Our Ref: 1160-8-25

Your Ref: Stage 3 (SSD 57703458)

**Re: Regents Park In-fill Affordable Housing – Stage 3 (SSD 57703458)
Response to submissions – Traffic.**

FIGURE 5-B99 SOUTH BOUND
RW2 AND HRV RHT RW2
NORTHBOUND

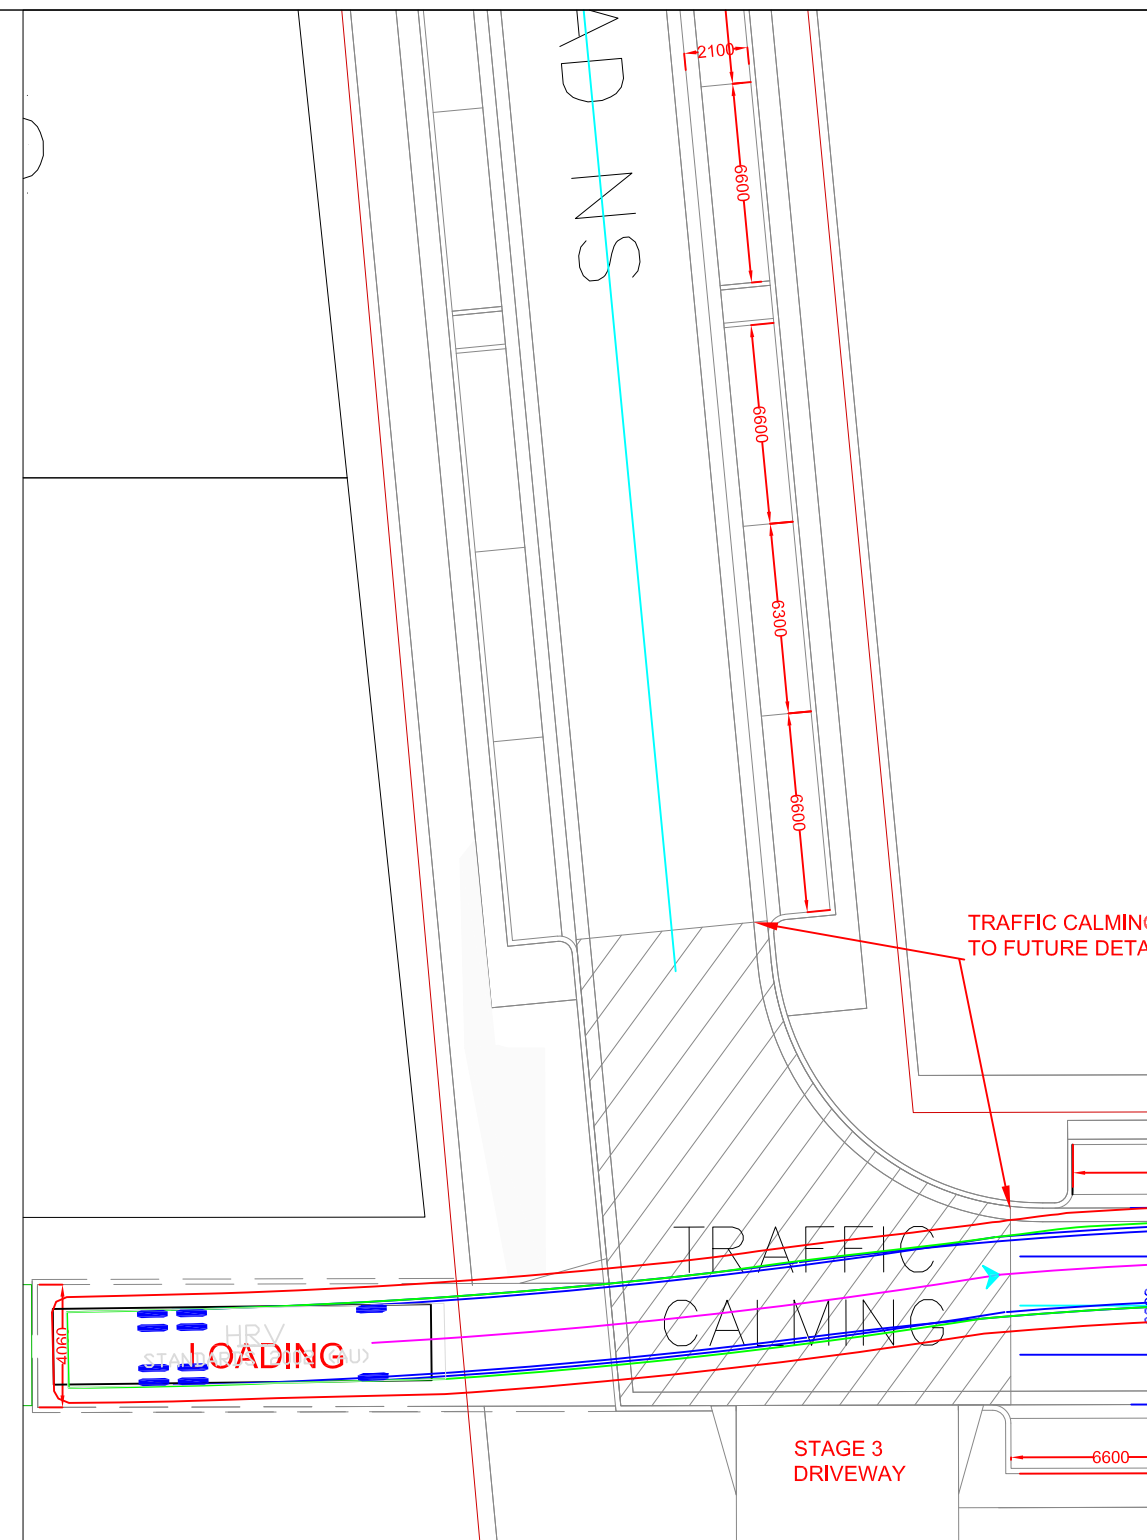
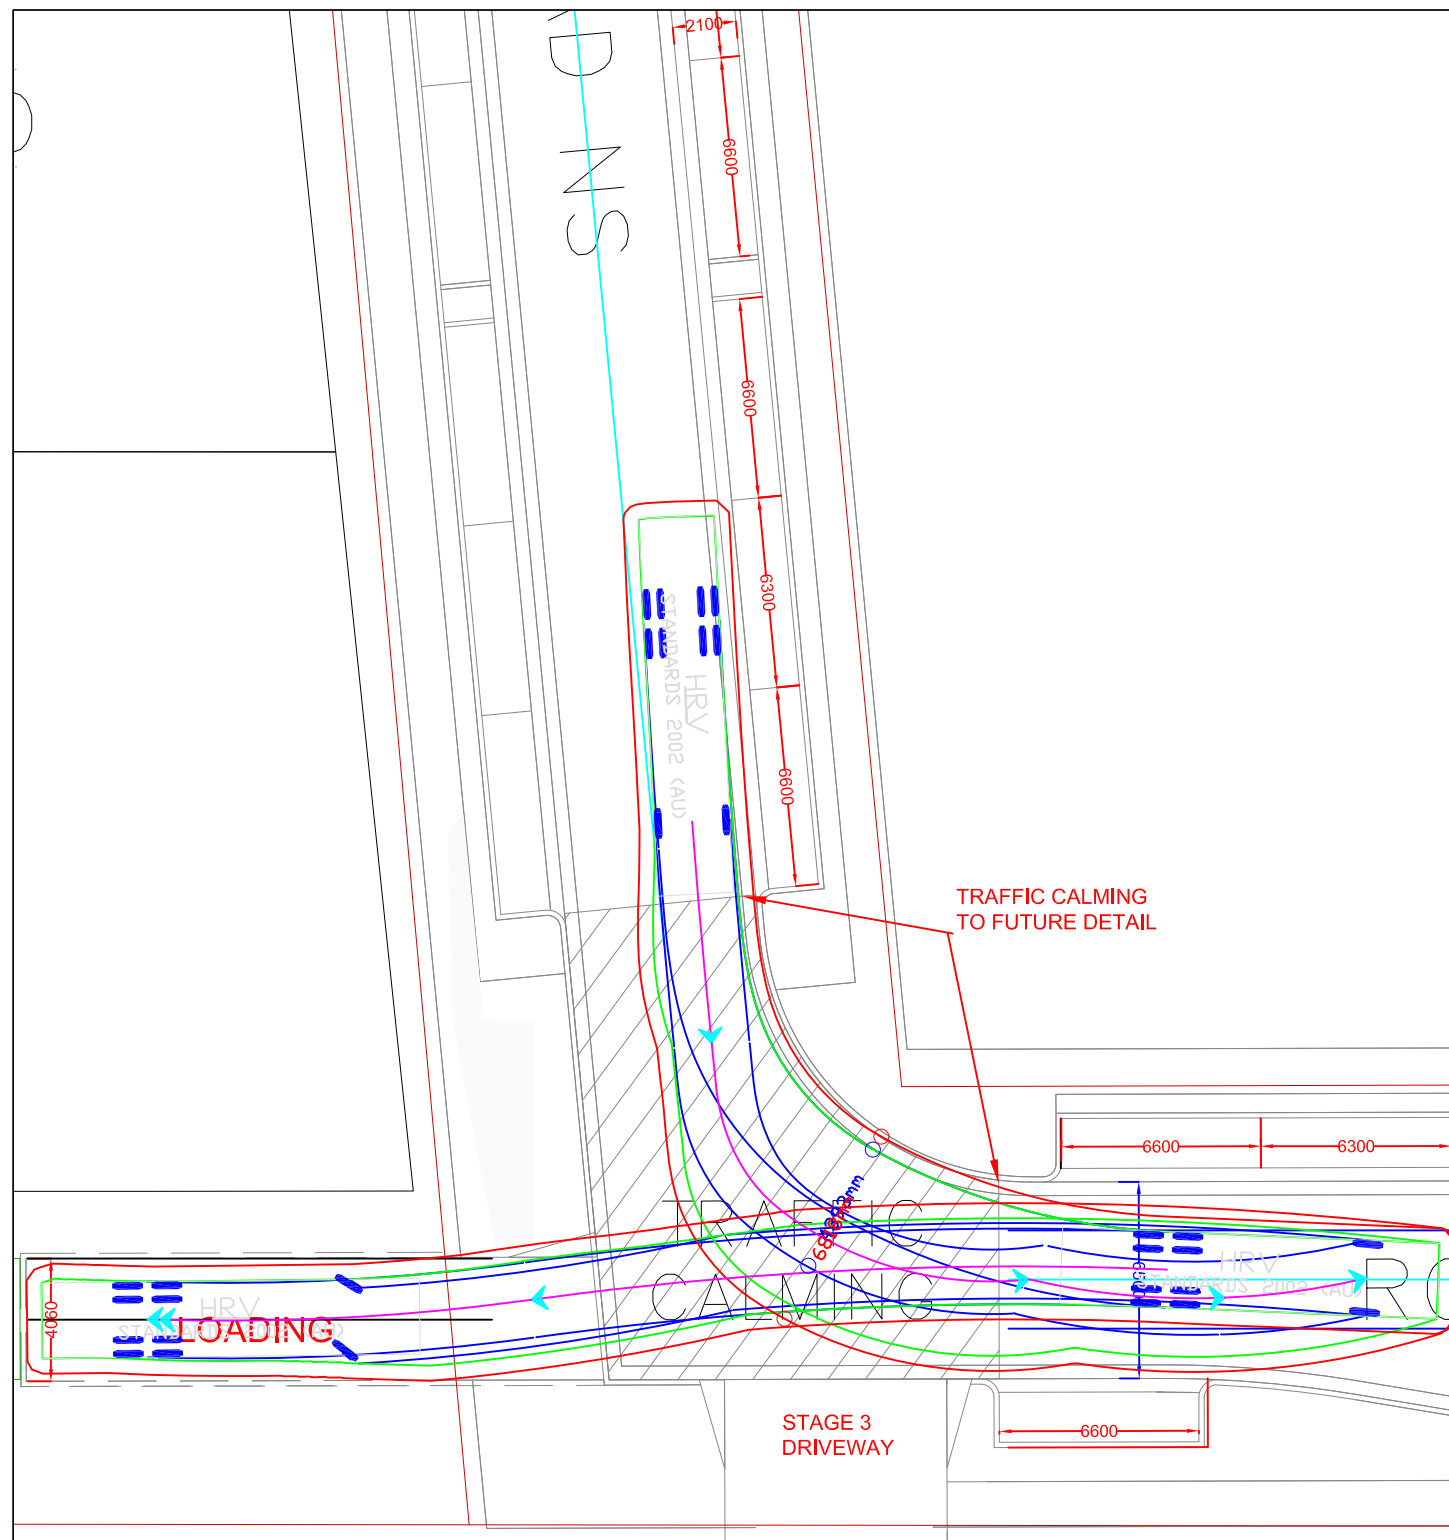
It is acceptable that the driveway width need not strictly comply with AS 2890.2. However, the Applicant must provide more legible and accurate turning path diagrams.

The submitted swept paths currently show significant overlap. The Applicant must demonstrate simultaneous entry and exit movements for a 12.5m HRV together with either a B85 or B99 vehicle for each driveway.

In addition, when a vehicle is waiting to turn right into the proposed site, the Applicant must clearly demonstrate that there is sufficient safe clearance for southbound vehicles to continue through without obstruction. The two internal roads must be wide enough to cater for footpath and services and in line with Council's standard. To be referred to Infrastructure Service.

It is noted that the on-street parking along the frontage of the site is being used for vehicles entering and exiting the property — effectively serving as merging and deceleration lanes.

Moreover, the deceleration area is shown within the existing Bus Zone, which is not acceptable. All turning paths must be designed and assessed so as not to intrude the Bus Zone (assuming a bus is stopped within the Bus Zone).

Turning paths needs to be reassessed and may require considering a wider driveway to improve safety at this location and predominantly avoid congestion and delays on Auburn Road.

Updated swept paths have been provided with the updated TIA included with the response to submissions.

The public domain design and articulation will form part of the scope of the Voluntary Planning Agreement (VPA) currently under discussion with Council. It is expected that the final road layout will be resolved consistent Council's expectations as part of this process.
